**KIRKLEES METROPOLITAN COUNCIL
INVESTMENT & REGENERATION SERVICE**

Reference No: 2021/62/92034/W

Site Address: 24, Rutland Road, Milnsbridge, Huddersfield, HD3 4RA

Description: Erection of single storey extension to rear and raised decking, demolition of existing conservatory and associated alterations

west elevation

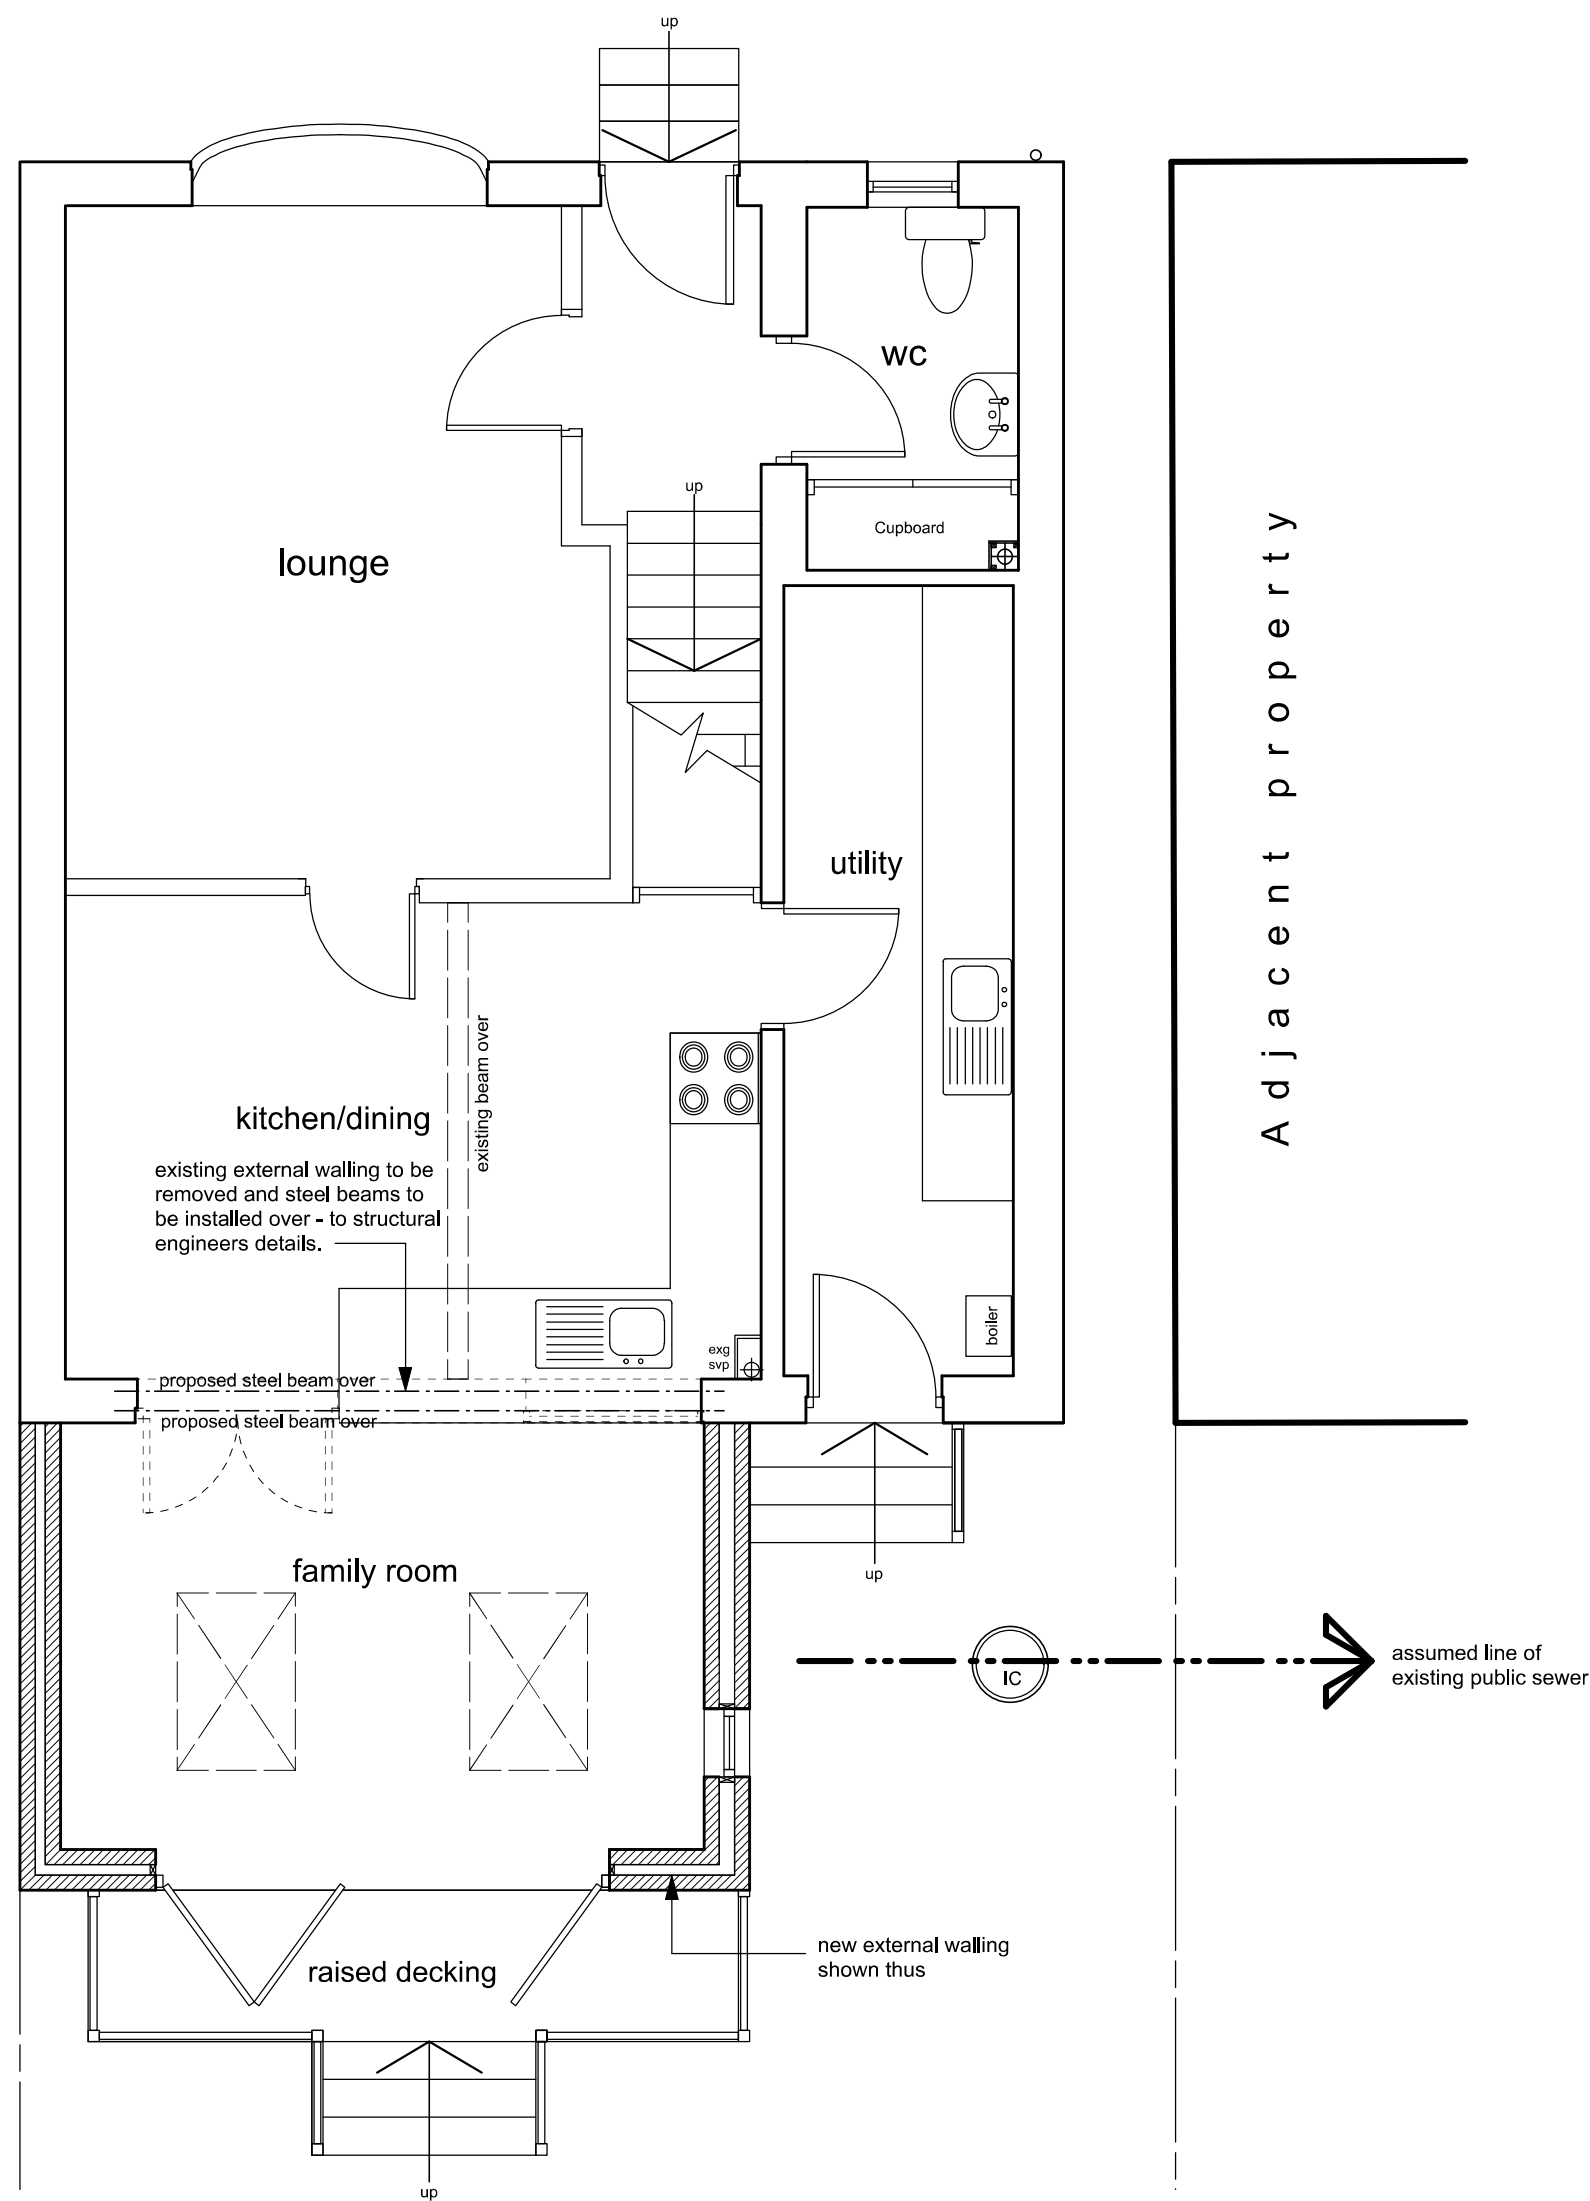
In this case there would be no windows in the side west facing elevation facing No.26, however the proposal shows a tall thin window in the east elevation facing No. 22, albeit the current conservatory has clear glazing facing the neighbours at No. 22, the new extension will be moved closer to the shared boundary and given the difference in levels would create overlooking at close quarters. Therefore, this window should be conditioned to be obscurely glazed to allow additional light into the room but to prevent overlooking of its neighbours. (condition 5)

5. The family room window in the side elevation of the extension hereby approved, shall be obscurely glazed (minimum grade 4), before the extension is first brought into use. Notwithstanding the provisions of section 55(2) (a) (ii) of the Town and Country Planning Act 1990 and the Town and Country Planning (General Permitted Development) Order 2015 (or any order revoking or re-enacting that Act or Order with or without modification) this window shall thereafter be so retained obscure glazed.
